# Grading & Erosion Control Plan\_V1.pdf Markup Summary

dsdlaforce (26)

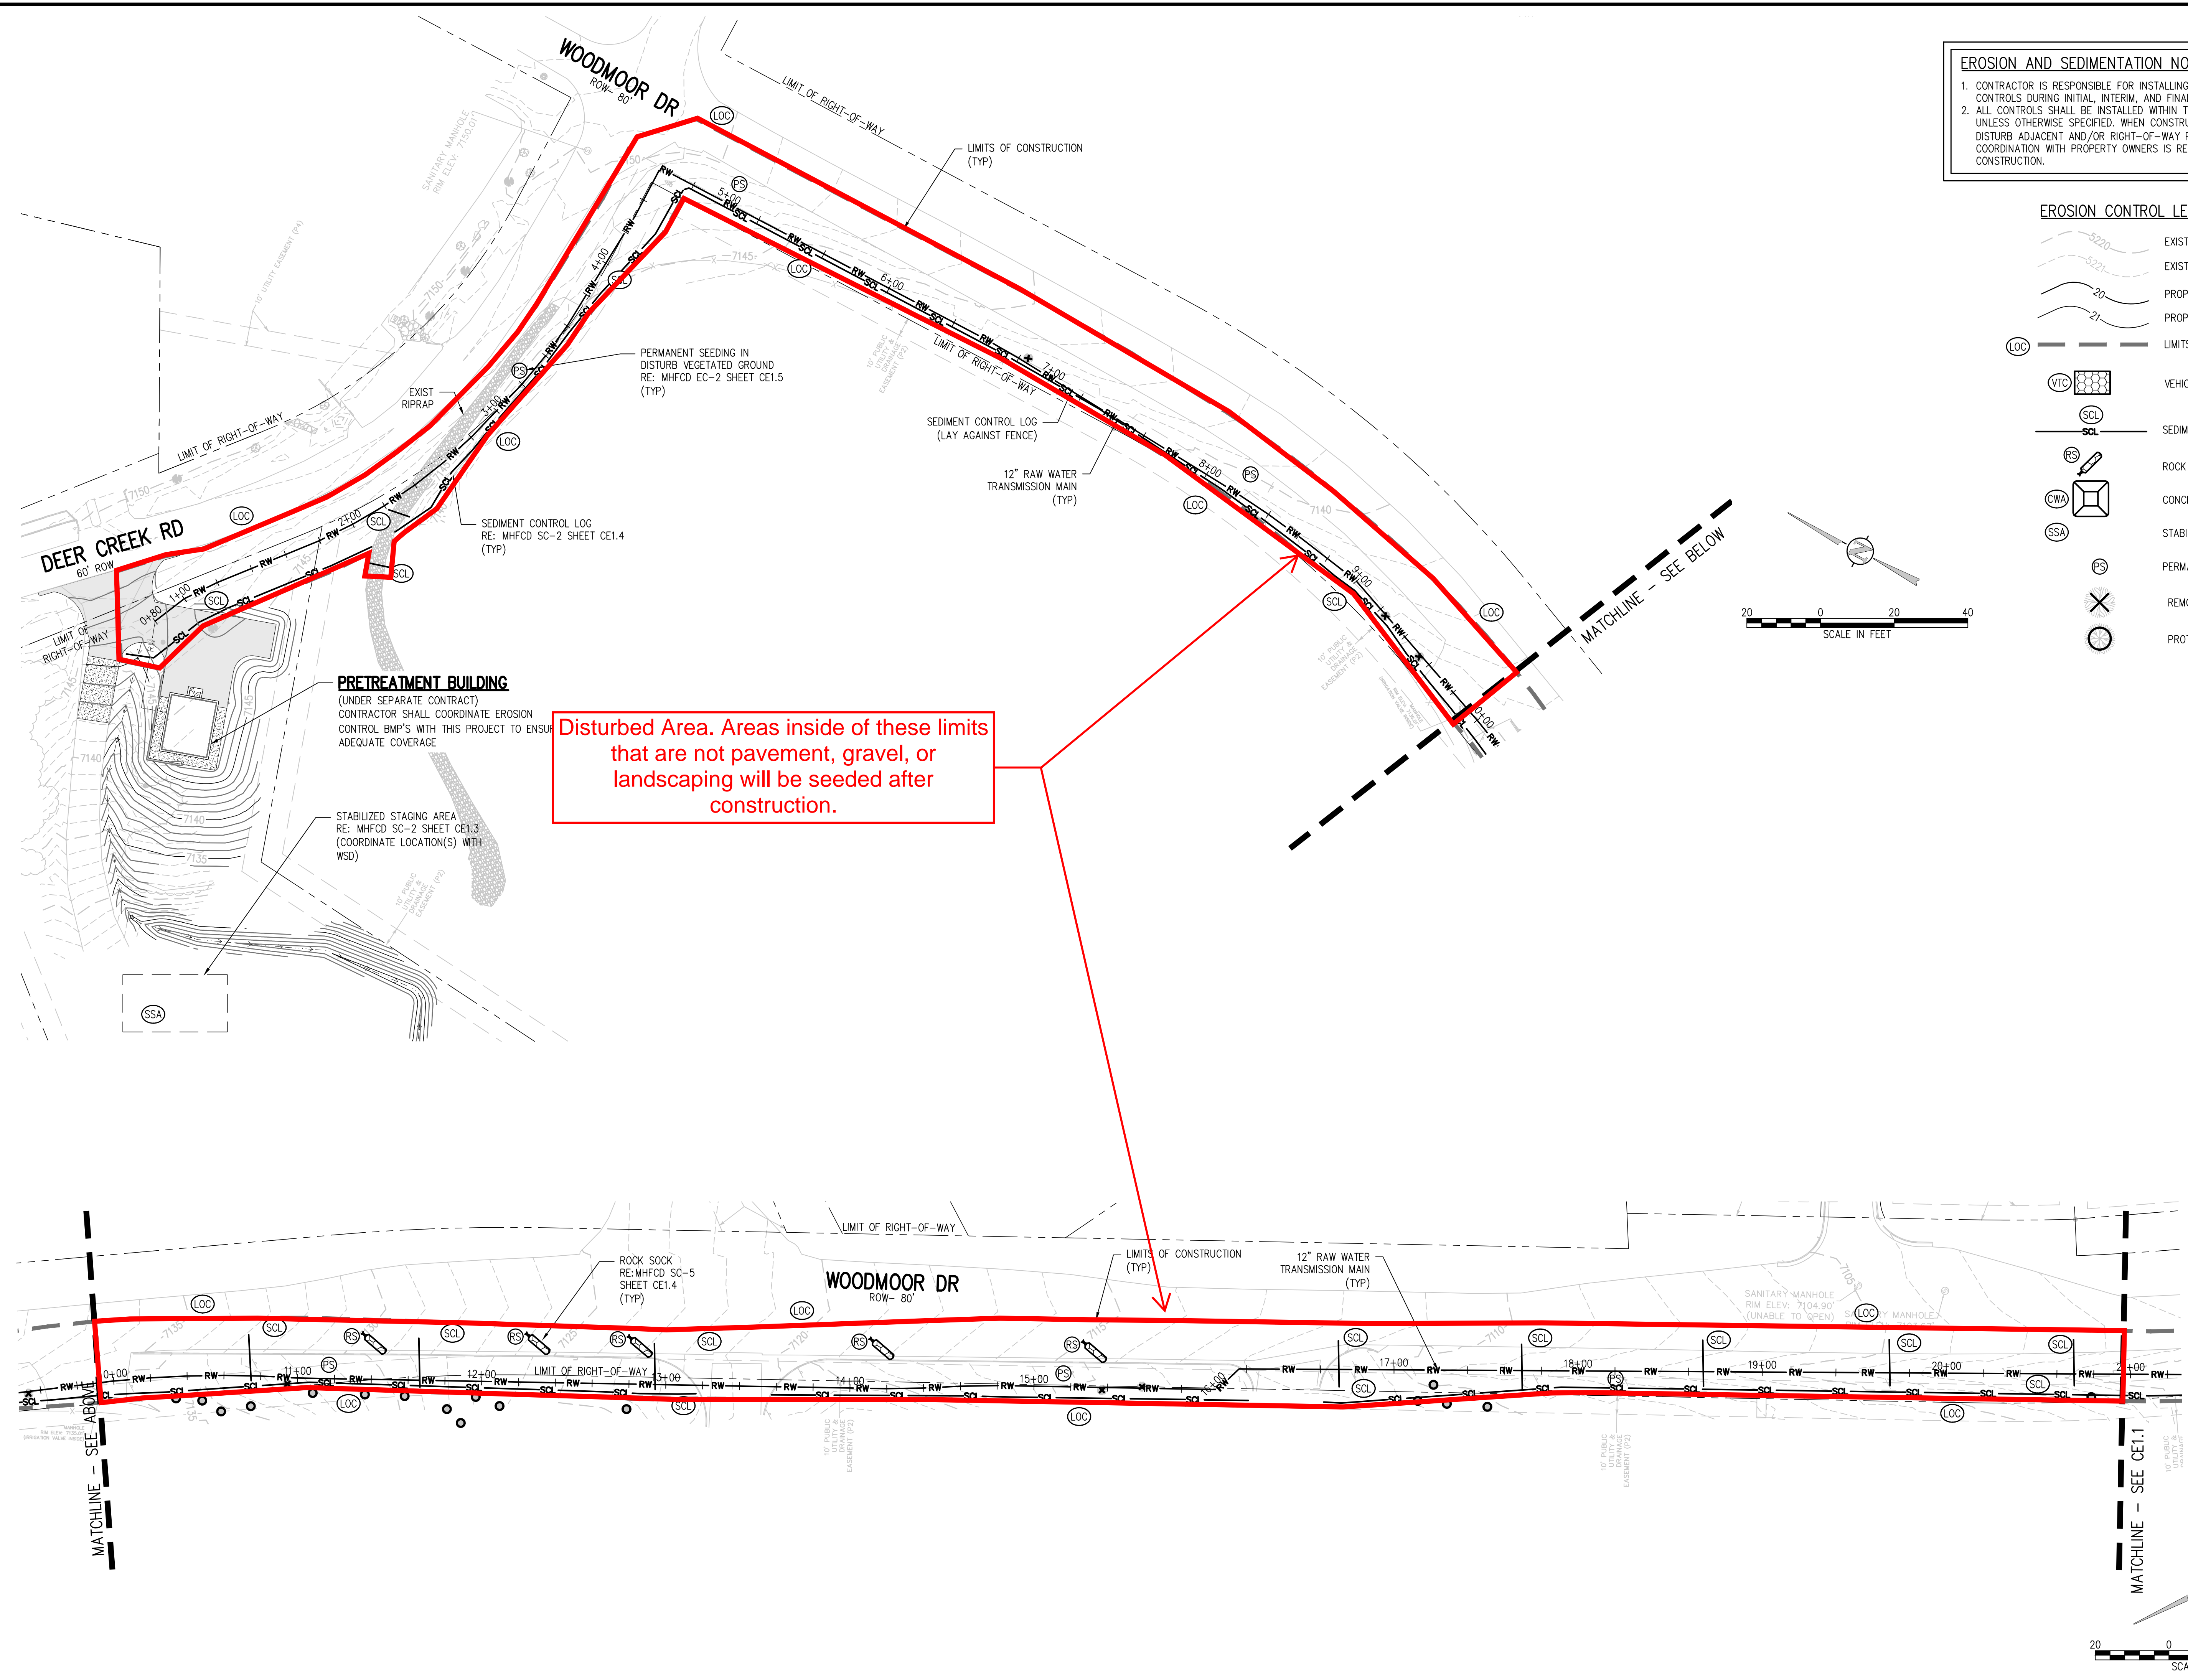
For legibility, update easement linework and label so it's darker.

Add crossspan detail

Add curb and gutter detail. See ECM appendix F for standard details

Provide a keymap

Label adjacent property (owner, parcel, address) along the raw water

linework doesn't seem to match aerial photo.

Call out areas to be restriped and patched.

Identify any and all surface improvements that must be removed/replaced.  
Identify the extents of removal & replacement

provide trench detail.

Provide pavement patch detail.

Show limits of pavement patch and rotomill along the RW.

NOTE: if the pavement patch extends to the wheel path then you must rotomill to the centerline of the road.

Label edge of asphalt.

In private properties, adjust limits of construction so it's within the public utility easement. WWSD must obtain permission/temporary construction easement from the property owner if construction extends beyond the easement.

Item H and M. If "limits of disturbance" and "construction boundary" are the same, change to "construction boundary/limits of disturbance" or otherwise show as separate linetypes for each on the legend and figure.

Show a sediment control measure like rock check dams across roadside ditch at appropriate spacing. And update FAE form accordingly. Typical for all areas with roadside ditch within excavation area.

Label as "Moorwood Point"

Typical all sheets:  
 - Checklist Item "b" - label some of the main adjacent Subdivision names/parcel numbers (and schools).  
 - Checklist Item "i" - Label specific areas on plans or just make a general note regarding condition of existing vegetation.  
 - Items f and g - show existing structures and utilities.  
 - Item p - Delineate cut/fill locations with linework on plans or make a note on plans (example: cut/fill not shown because most of the project will be excavating and backfilling a trench. However, mostly fill will take place around Pump Station #2.  
 - Item s - show stormwater flow direction areas (including on properties adjacent to Limits of Construction so it is clear where runoff/runon occurs), on plans and Legend.

SHEET NO.
CE1.1

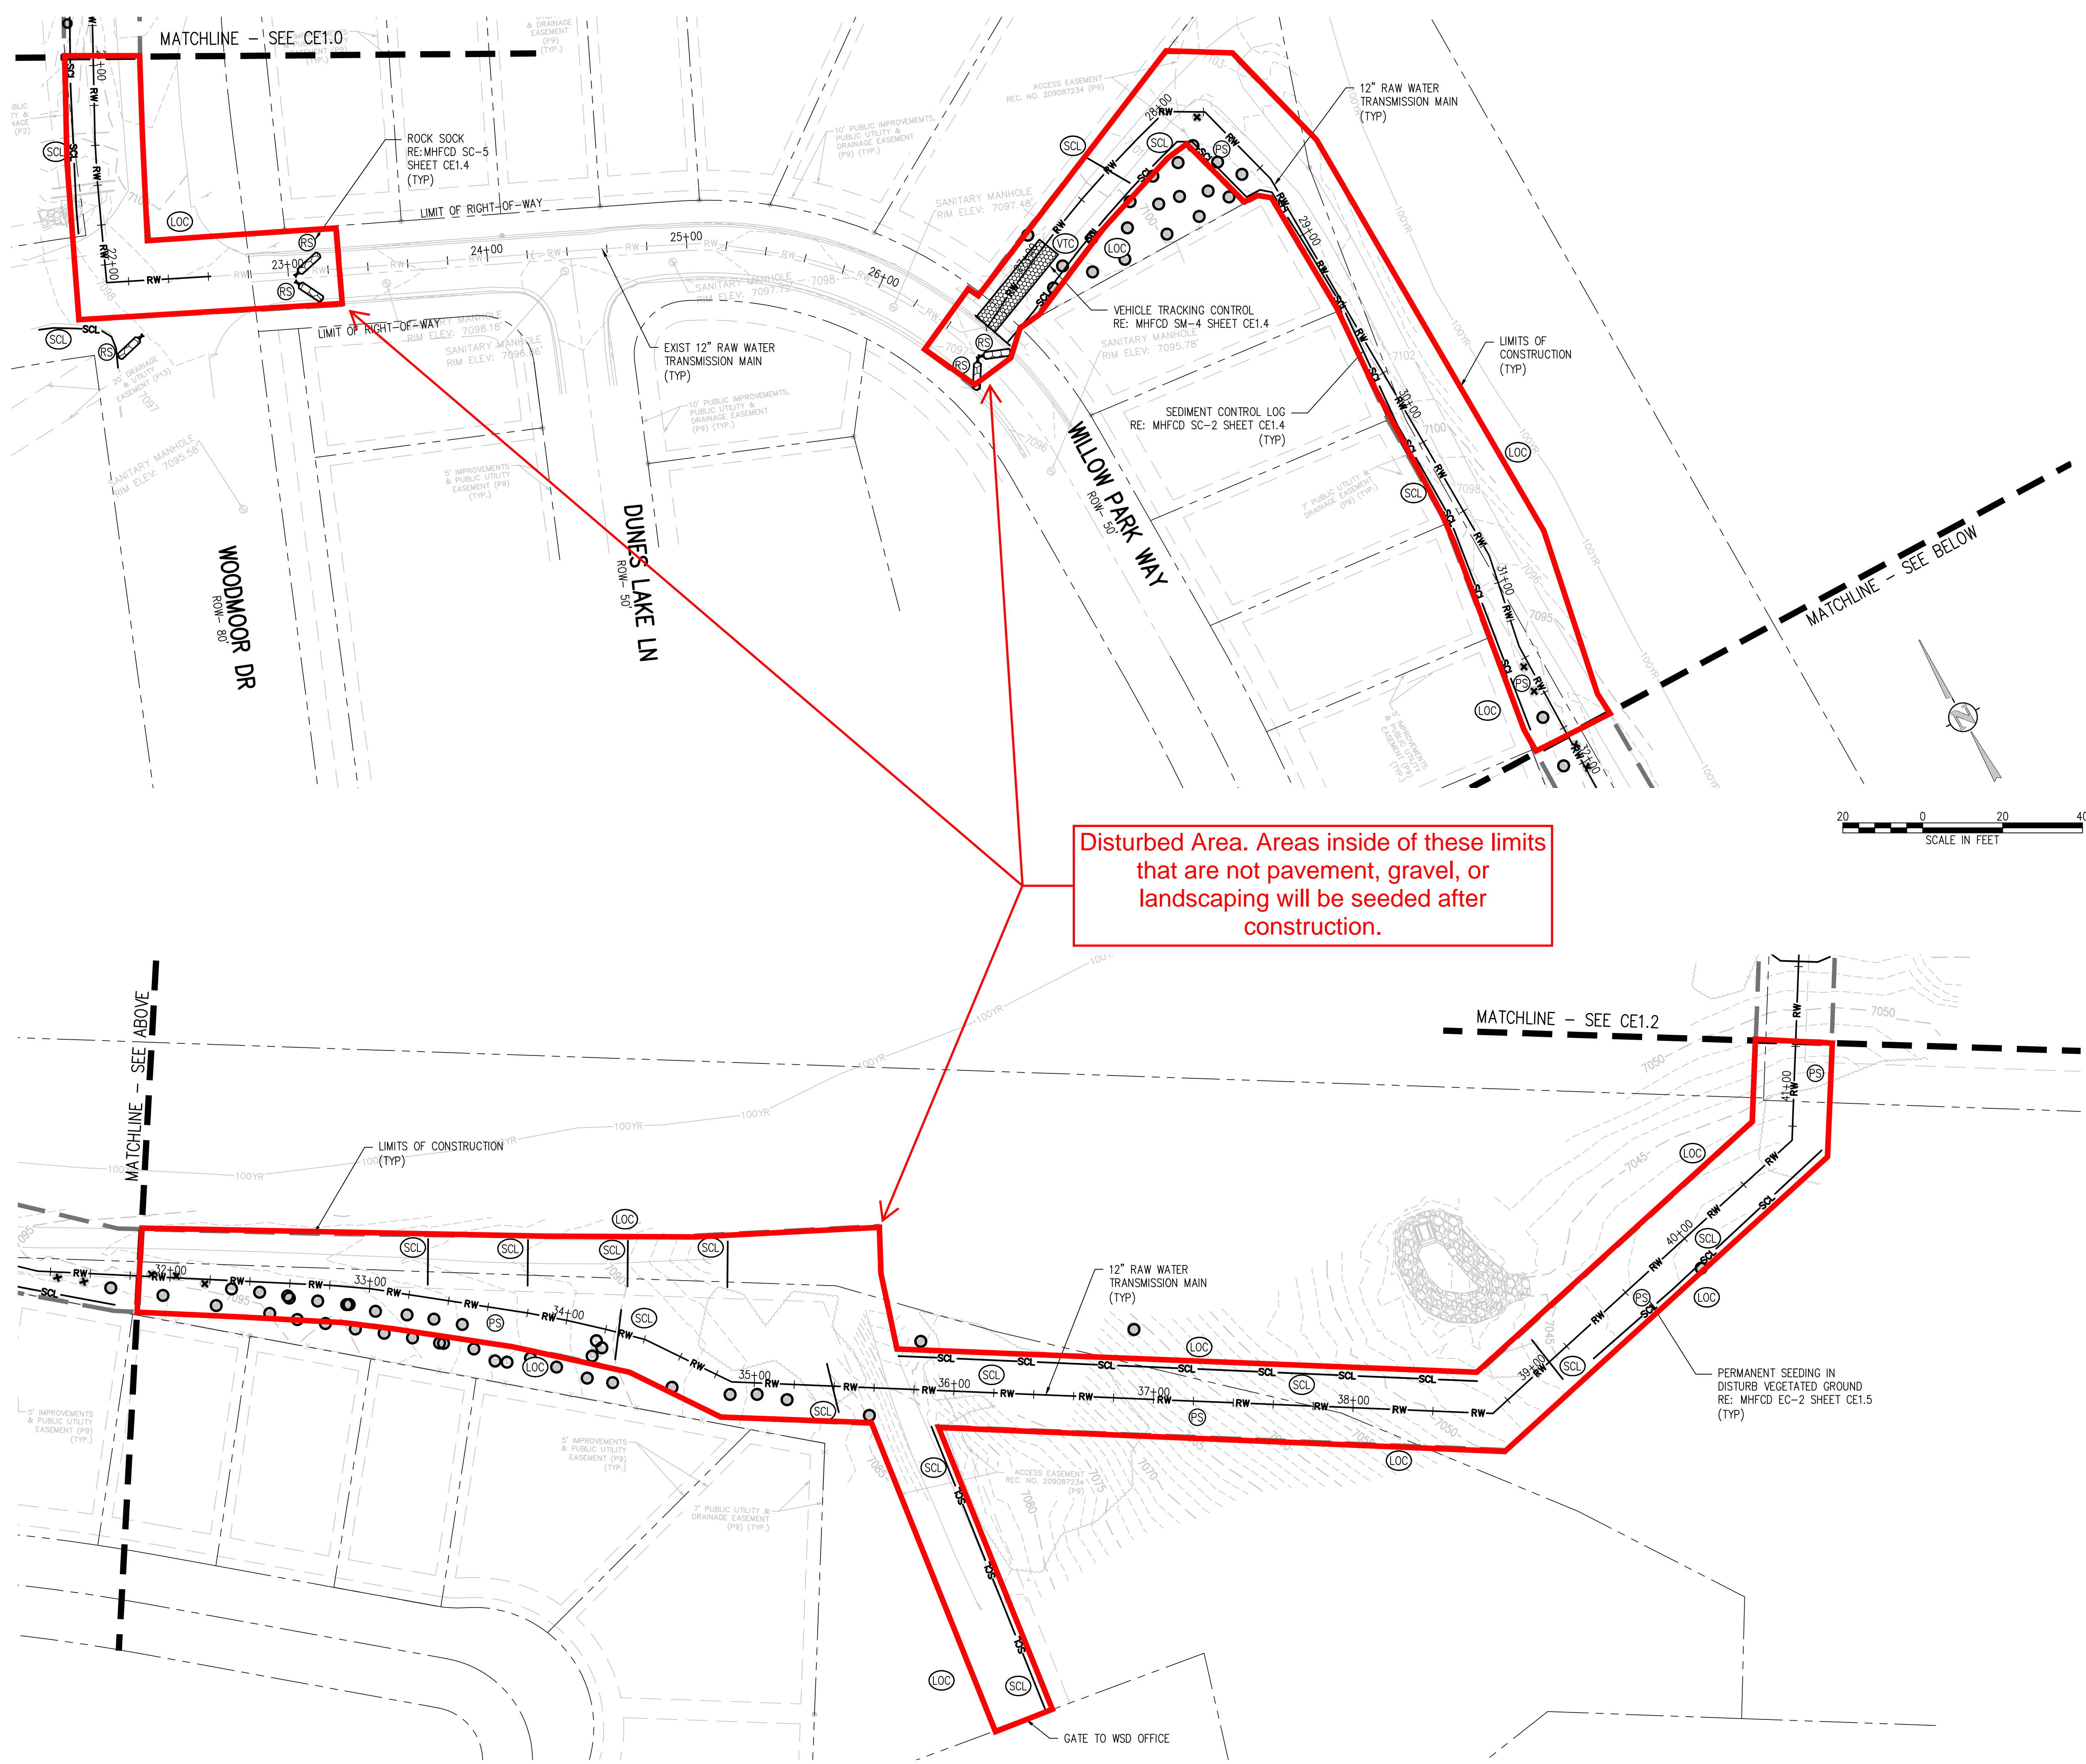
show limits of patch and rotomill

Label adjacent property (owner, parcel, address).

Alternative with adjacent property being multiple lots is to label the lot numbers and tracts and identify the subdivision with plat number

Identify if the curb&gutter is protected in place or removed replaced.

Identify remove and replace of sidewalk. Provide the quantity or extent.

show and label existing sidewalk

Identify trees to be protected in place or removed/replaced.

Identify trees to be protected in place or removed/replaced.

Add linetype to legend

Drawings don't appear to be at 1in=20ft scale as notated, since at that scale, 1 Station = 50ft. Revise scale bar.

Note that per details VT-1 and VT-2 in DCM Vol. 2, Chap 3.3, VTC should be 75ft min length. Shown here as 50ft. Revise.

Vehicle Tracking Control (VTC) SM-4

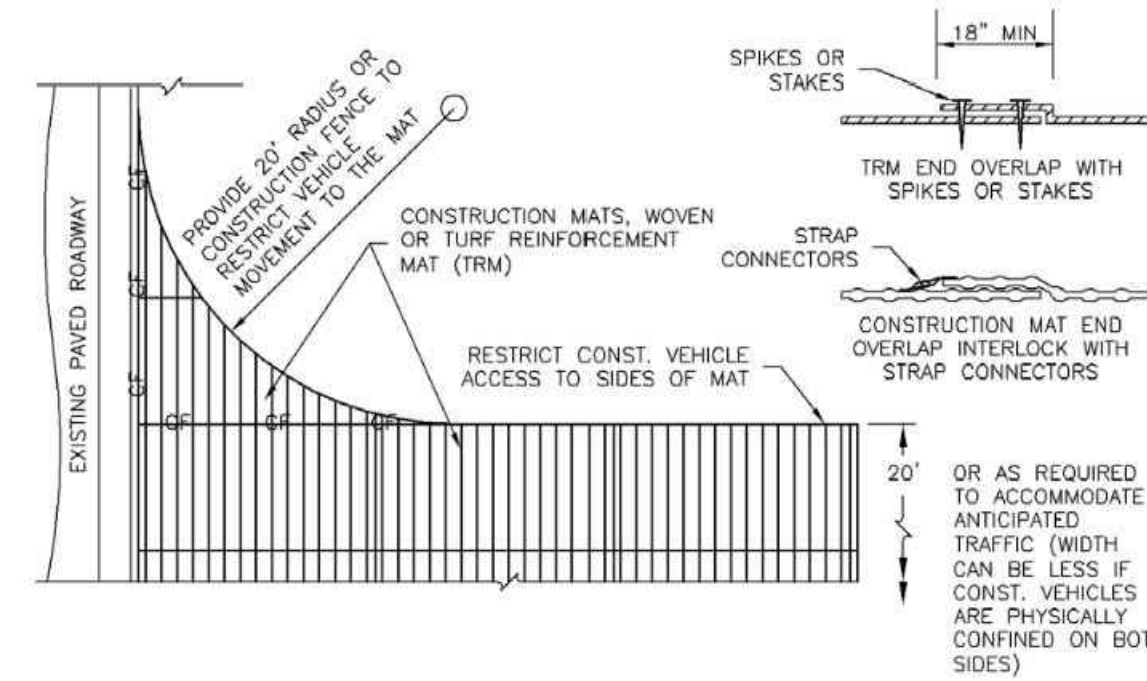
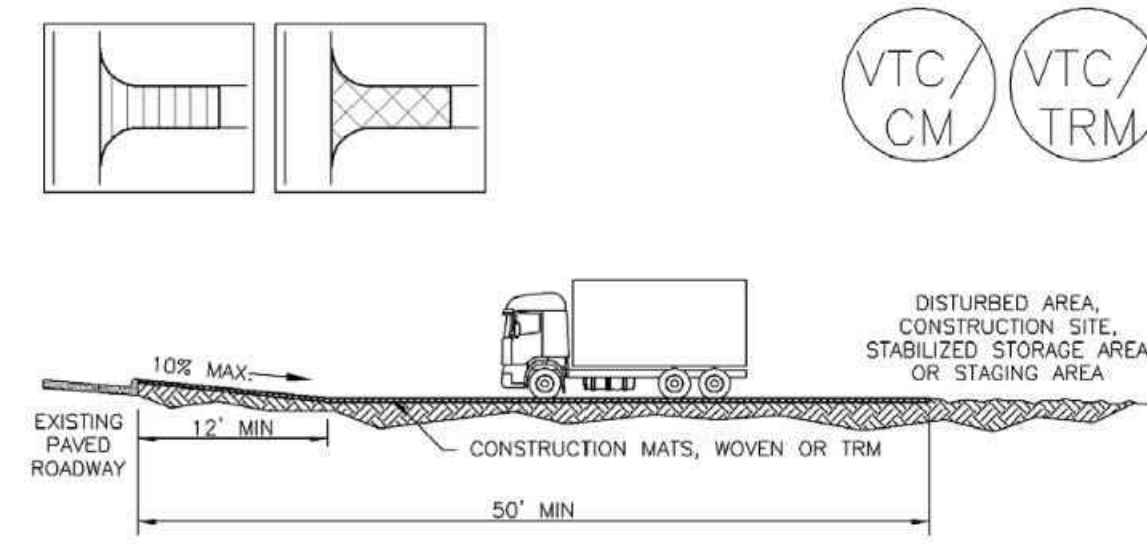
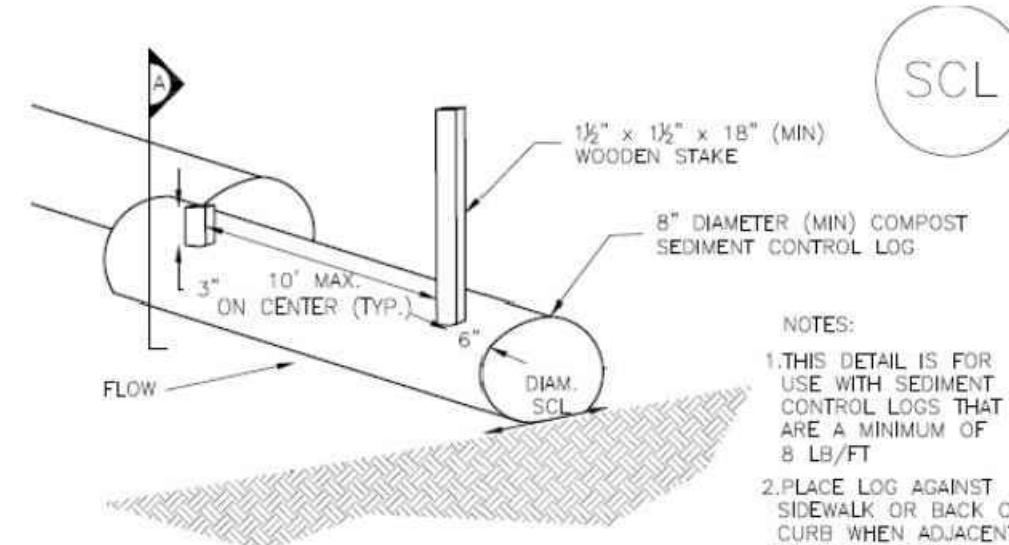
VTC Detail: Make sure whichever VTC detail is selected is shown with a 75ft min length
